**Peaks Island Elementary School - 4 Church Ave. - Permit #2017-00471**

GENERAL SITE PLAN

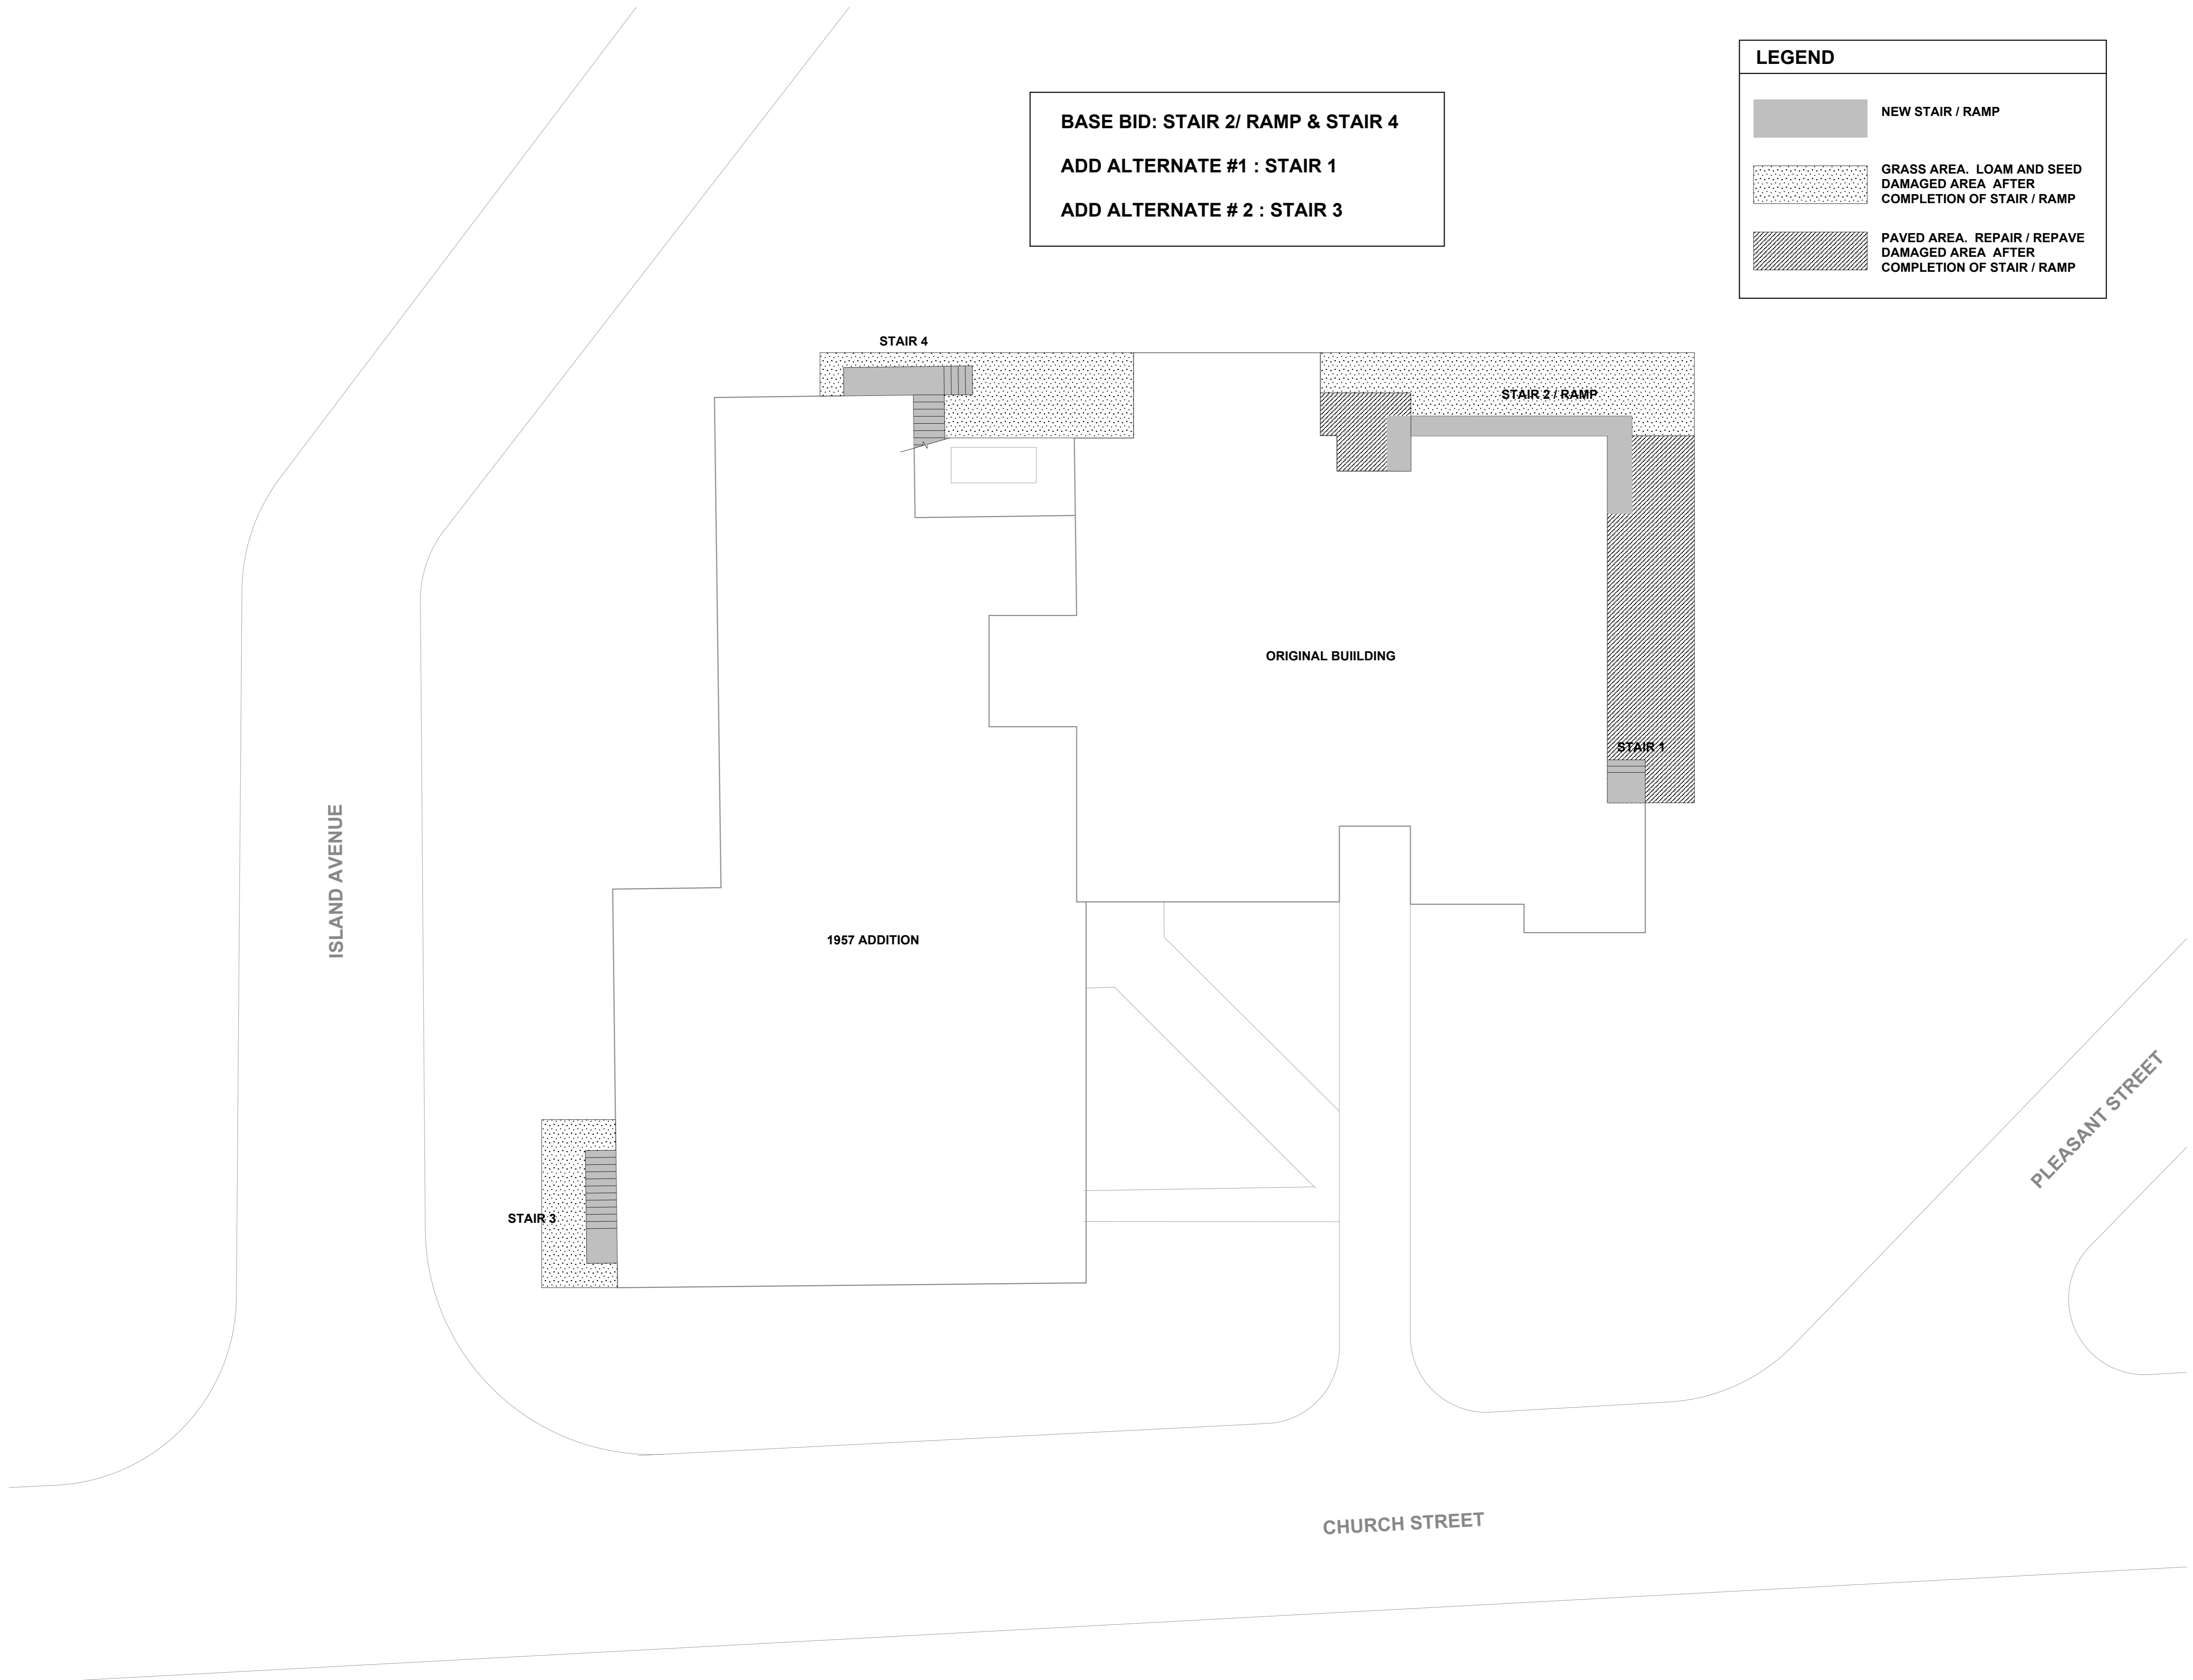
*We asked for an administrative authorization for the Peaks Island Library and Reiche school. Let's do that here as well. I would like to have the calculation of the square footage of the replacement steps and the ramp. I did not see that in the application.*

I have looked at the site plan in the building permit and I am ok with the plan. I can sign off for planning on the building if you want Ann. I will not ask for an administrative authorization application for the ramps and steps.

Stair #2 - 119 Total sq ft for new Stairs and landings.

Stair # 4 - 292 Total sq ft for new ADA ramp and landings.
